Michael Rowe
JBA Urban
Level 7 / 77 Berry Street
North Sydney NSW 2059

03 February 2016

Subject: One Carrington Street – Response to Section 96 modification comments

Original tower facade concept diagram - two facade types

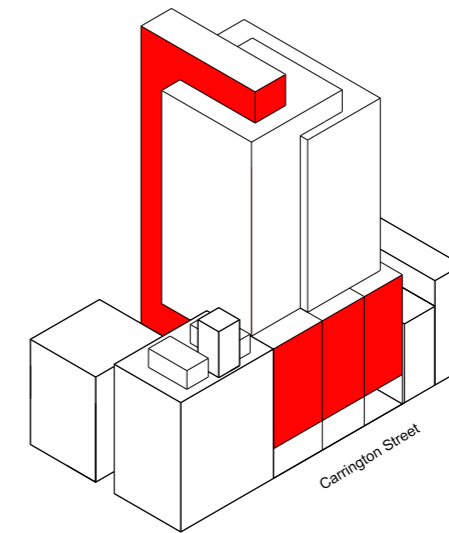
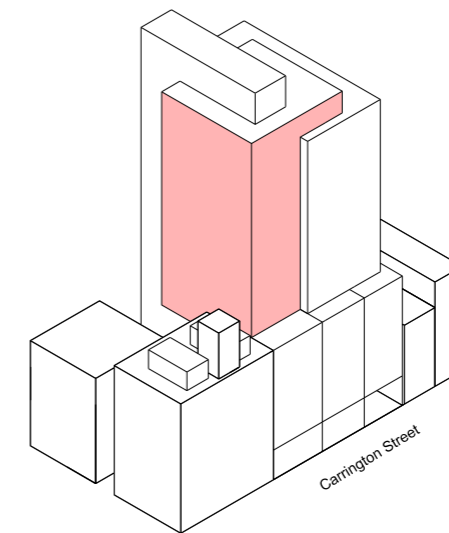
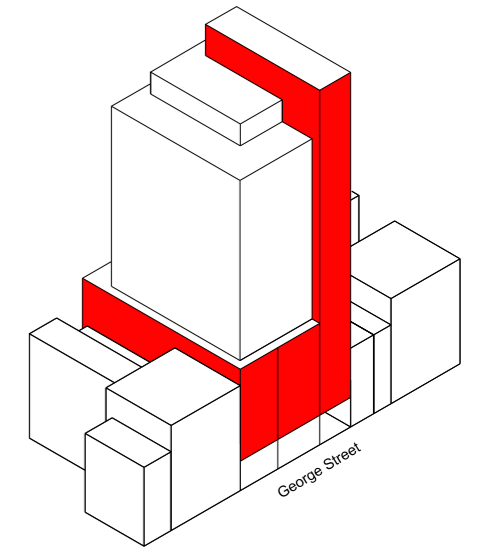
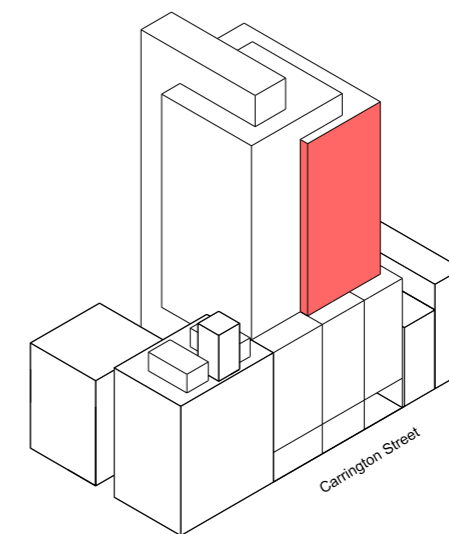
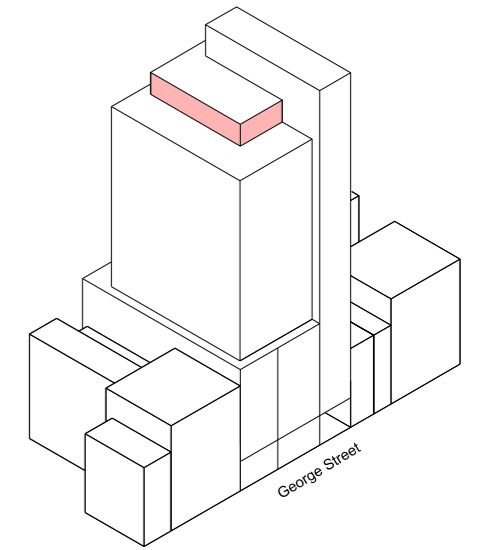
We would like to address the Departments comment regarding the design development of the façade. The approved design is comprised of three interlocking blocks. These are arranged to form the architectural expression of the building massing. Previously in the approved scheme the proposal was to apply two façade treatments to the three blocks. The two types consisted of 300mm and 100mm deep fins projecting from each mullion at 1.5m centres. Each of the facade type (fin depth) was applied to the opposing faces of each block. Refer to the extract from the original Design Statement below (page 25).

The diagrams above display the nature of the façade application and highlight that in some cases the same façade type reads on a single elevation. In order to achieve greater contrast and identity between each of the three blocks, the concept has been developed to provide three façade types unique to each block. This improves the contrast between each of the blocks. Please refer to the revised diagrams on the next page.

The depth of the fin for each façade type has been controlled to achieve a hierarchy for each block. Previously each block was treated equally with the two façade types applied to all. The deepest profile has been assigned to block A which contains the podium and tallest block of the buildings massing. The 200mm deep fins provide a greater degree of shading for the taller block and the perception of solidity on the podium when viewed along the street. The 100mm deep fin is assigned to block B which primarily faces north and west. This offers a level of shading to the façade while distinguishing itself from block A. Block C primarily addresses the south and uses a 15mm vertical capping at 1.5m centres to enhance the vertical articulation of the block.
